**Town and Country Planning Act 1990
Application for Permission to Develop Land**

Response from Pollution & Noise Control

PNC Reference No:	WK/201603695
Name of Planning Officer dealing with the matter:	Adam Walker
Application Number:	2016/62/90502/W
Proposed Development:	Internal and external alterations to barns to form one dwelling
Location:	Springhead Farm, Scholes Moor Road, Hade Edge, Holmfirth, HD9 1RU
Date Required By Planning:	11th March 2016

Client: Mr & Mr P Crompton	
Project: Spring Head Farm Scholes	
Drawing: Proposed Layouts	
Date: Jan 2016	Scale: 1:100 @ A3
Drawing No: 1579/111	Rev:

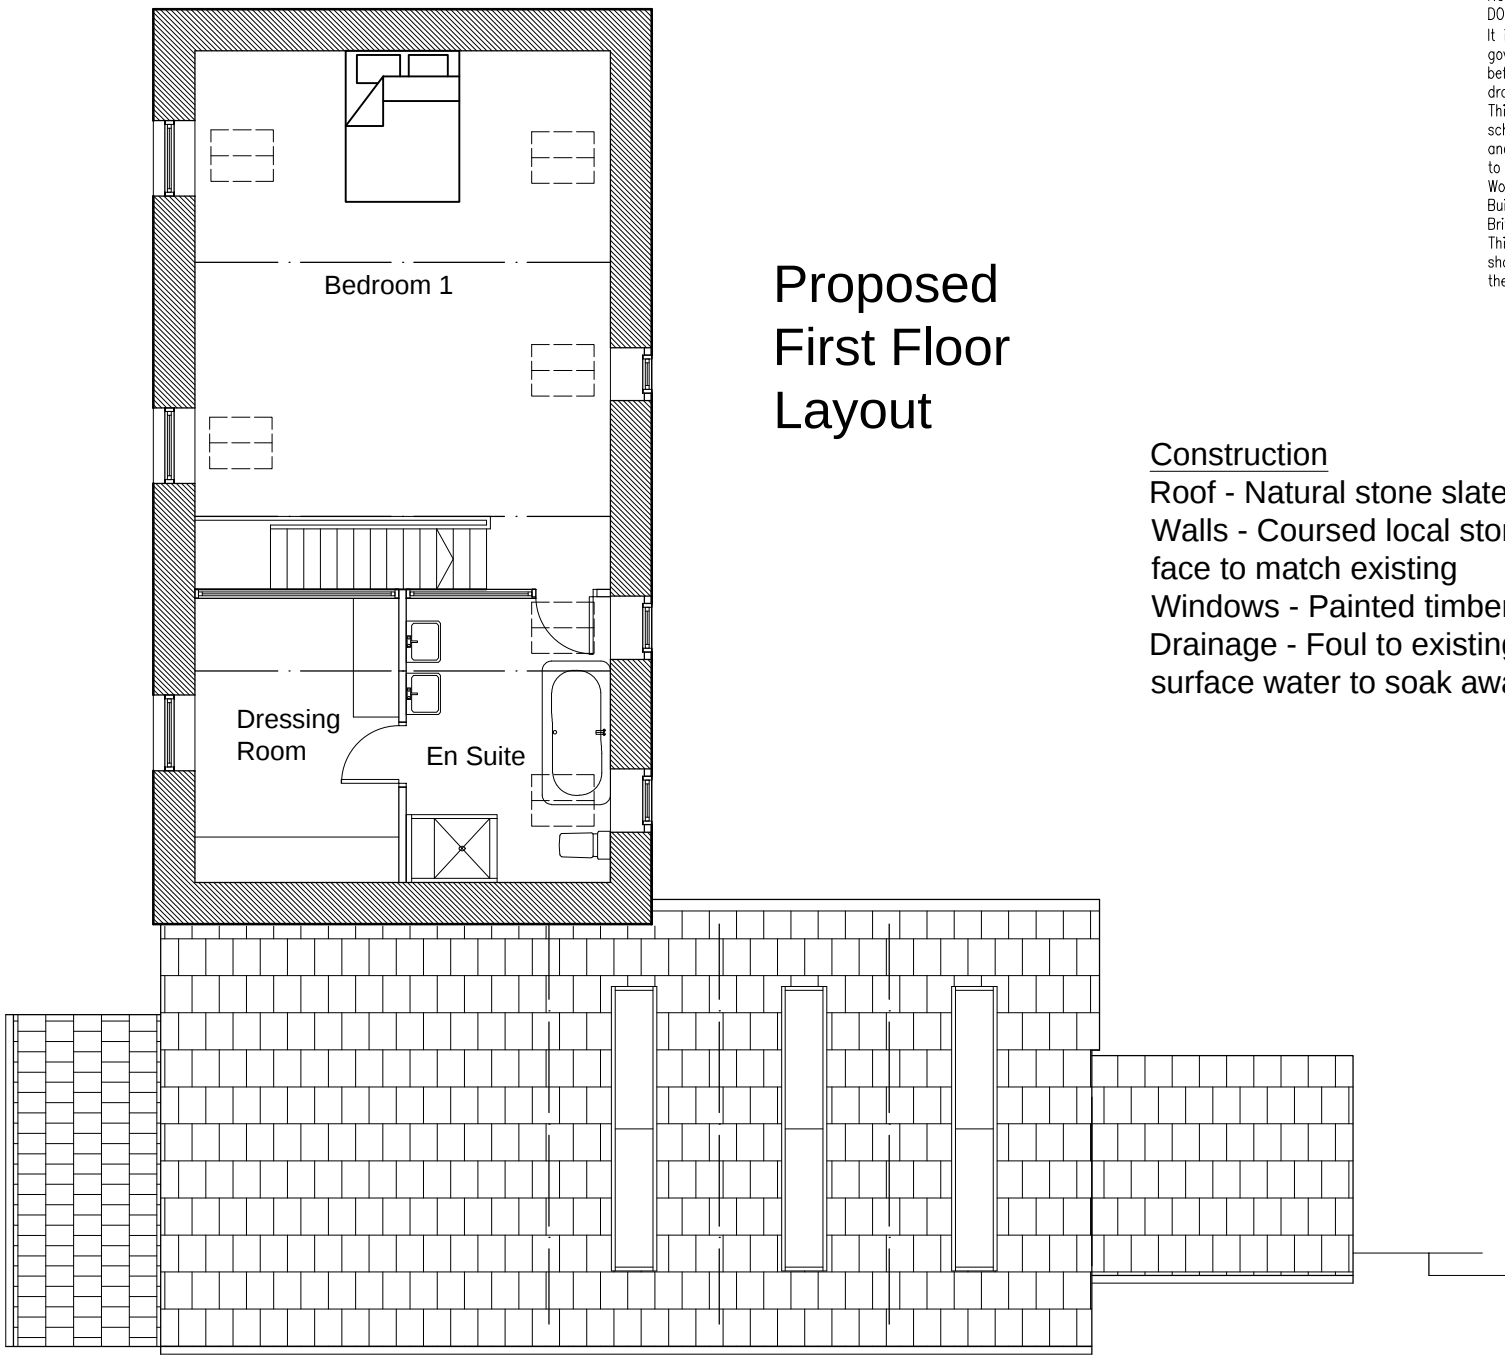
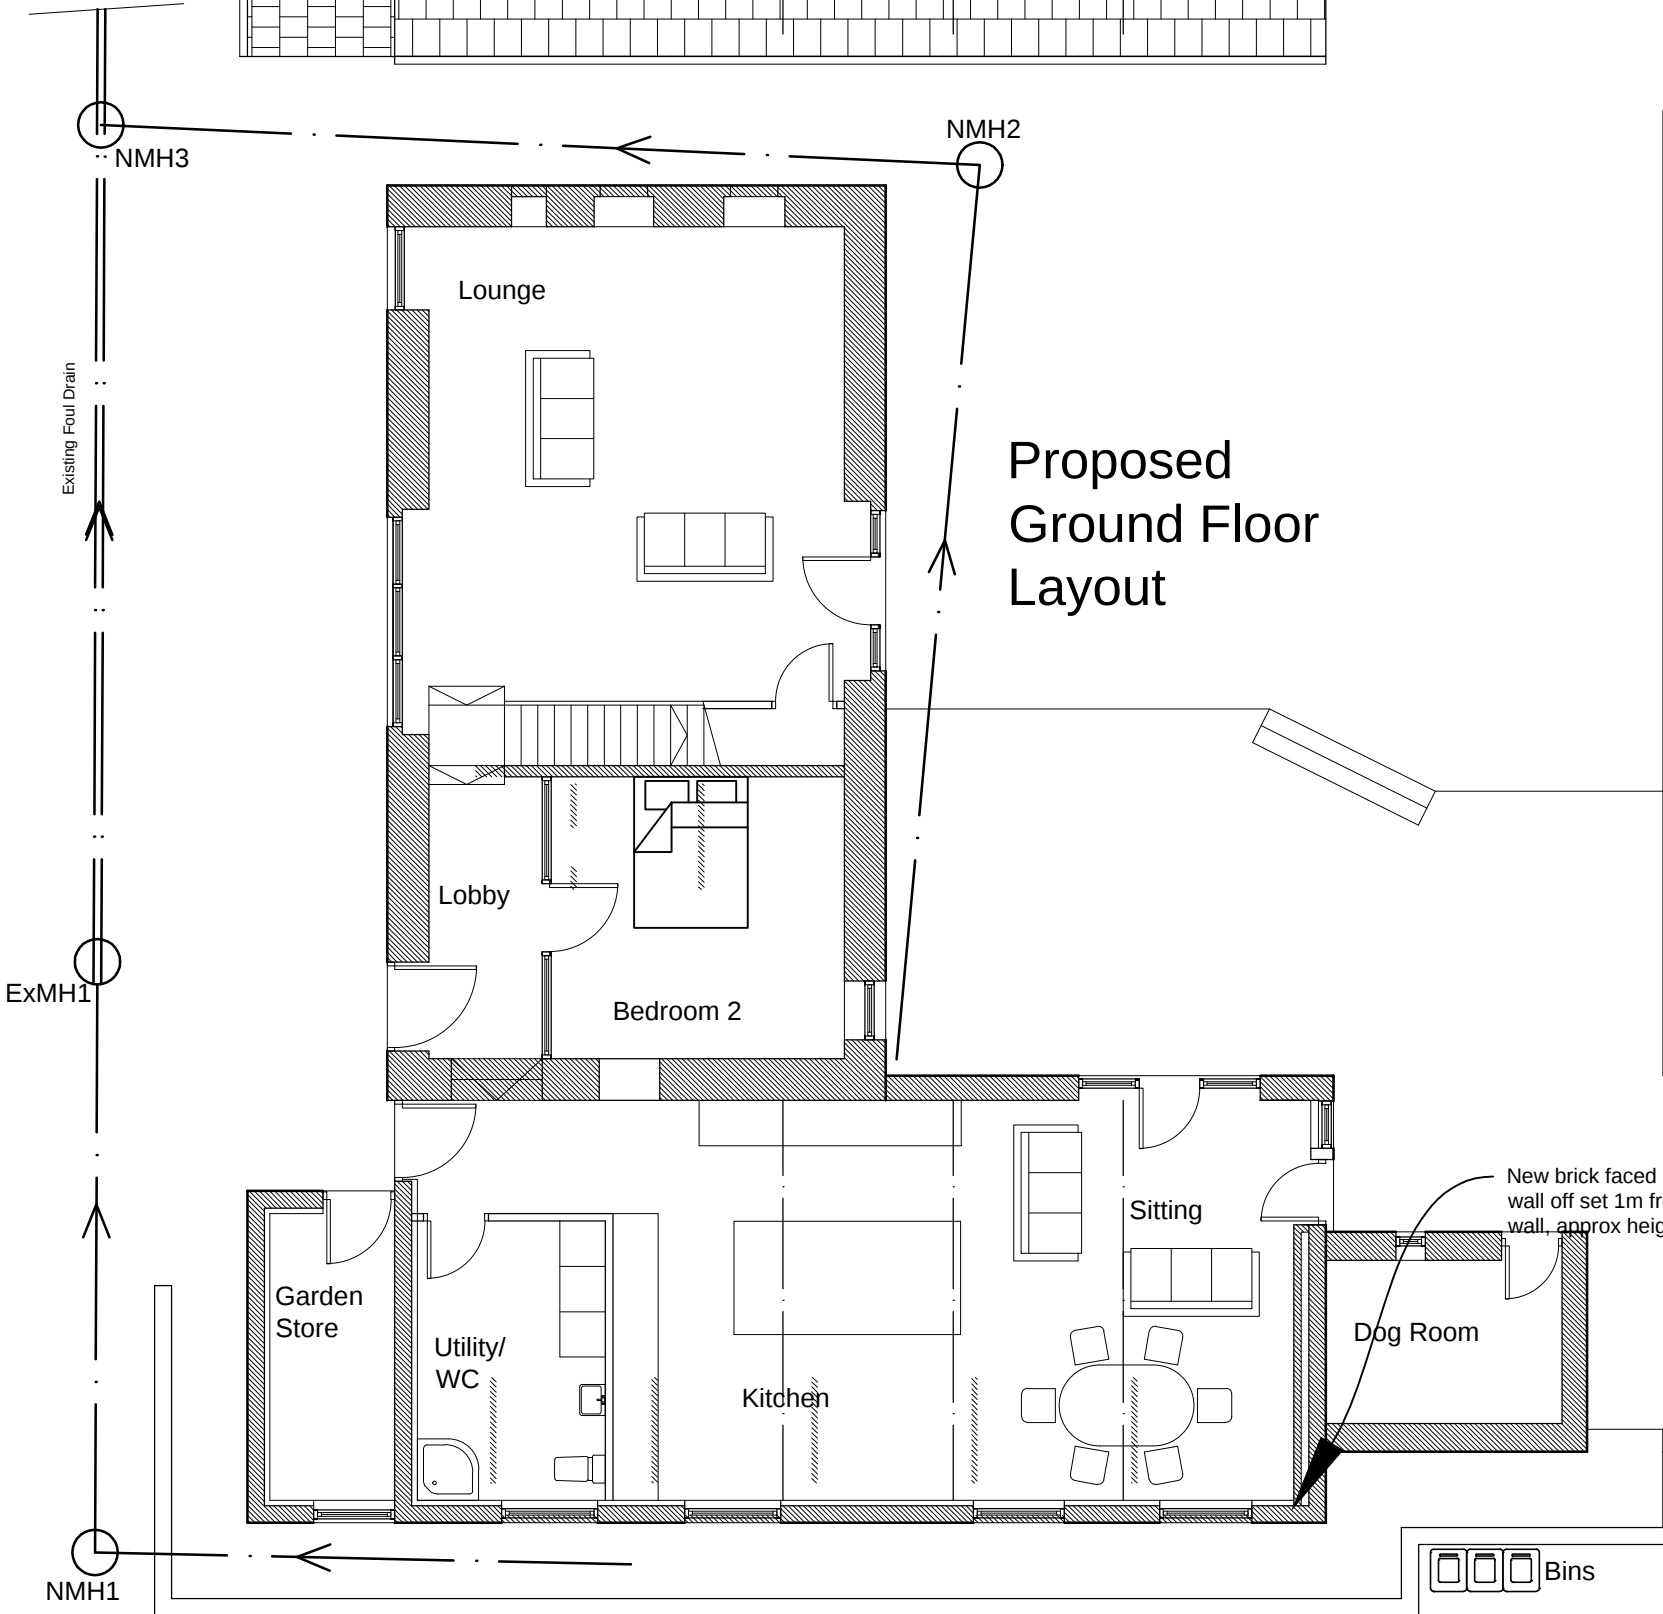
I have no concerns about this development, other than the lack of information regarding the foul water disposal. It is not sufficient to simply say "Package Treatment Plant" with no details.

In this instance I cannot see why a connection to the Yorkshire Water main sewer cannot be made. According to our records there is a main sewer and manhole approximately 12 metres East of the application building (crossing the applicants field)

The applicant has given no information as to why a mains connection is not possible as this option is the preferred option here. Prior to the granting of permission I would like to see this

Client: Mr & Mr P Crompton	
Project: Spring Head Farm Scholes	
Drawing: Proposed Site Layout	
Date: Jan 2016	Scale: 1:200 @ A3
Drawing No: 1579/110	Rev: C

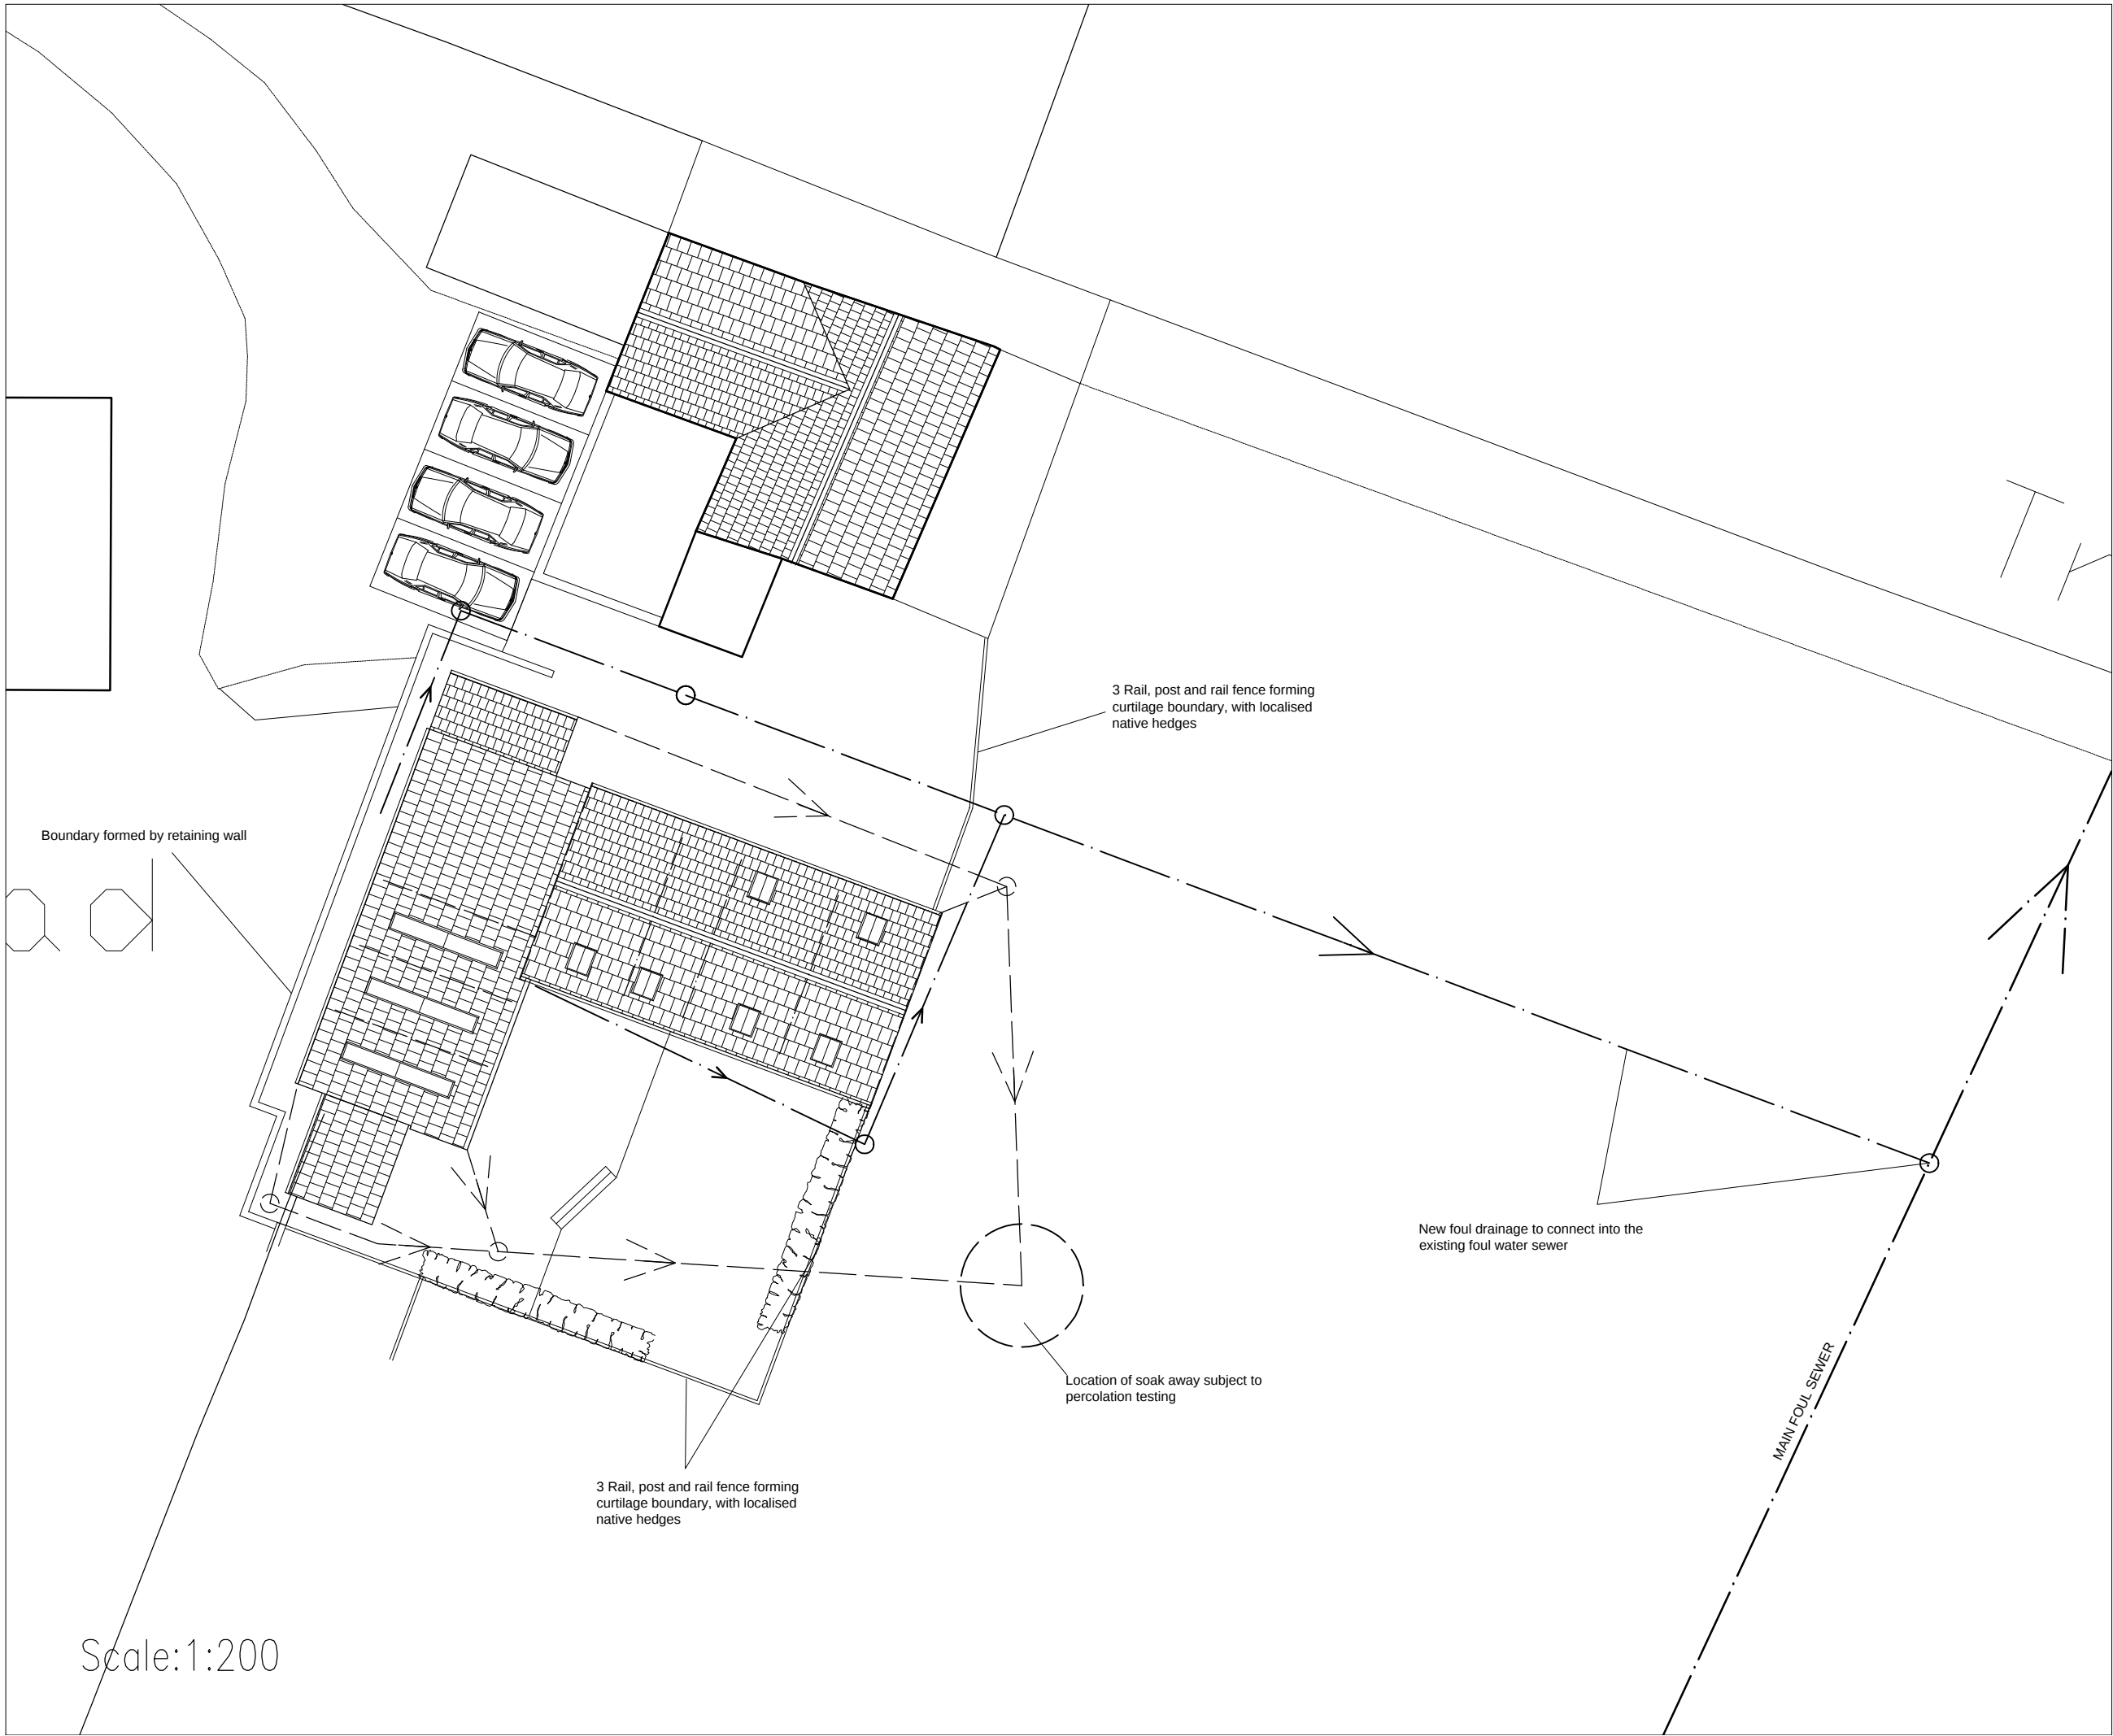
option explored and if it is not practical or financially viable, then evidence should be provided to demonstrate this.

If the above is the case (unable to connect to Yorkshire Water Main Sewer), then I will recommend the following condition be applied to any consent granted:

Before development commences, the applicant shall submit a report giving details of the packaged sewage treatment plant to be installed, & that it be agreed in writing with the LPA.

In particular the following information should be included:

- 1 location of the tank. If the location is near to any well, stream or river it is Recommended that the environment agency be consulted about the application.
- 2 the capacity of the tank and number of persons using the tank.
- 3 adequate means of vehicular access should be provided to allow the tank to be Emptied.

The installation shall be installed and maintained in accordance with the agreed details.
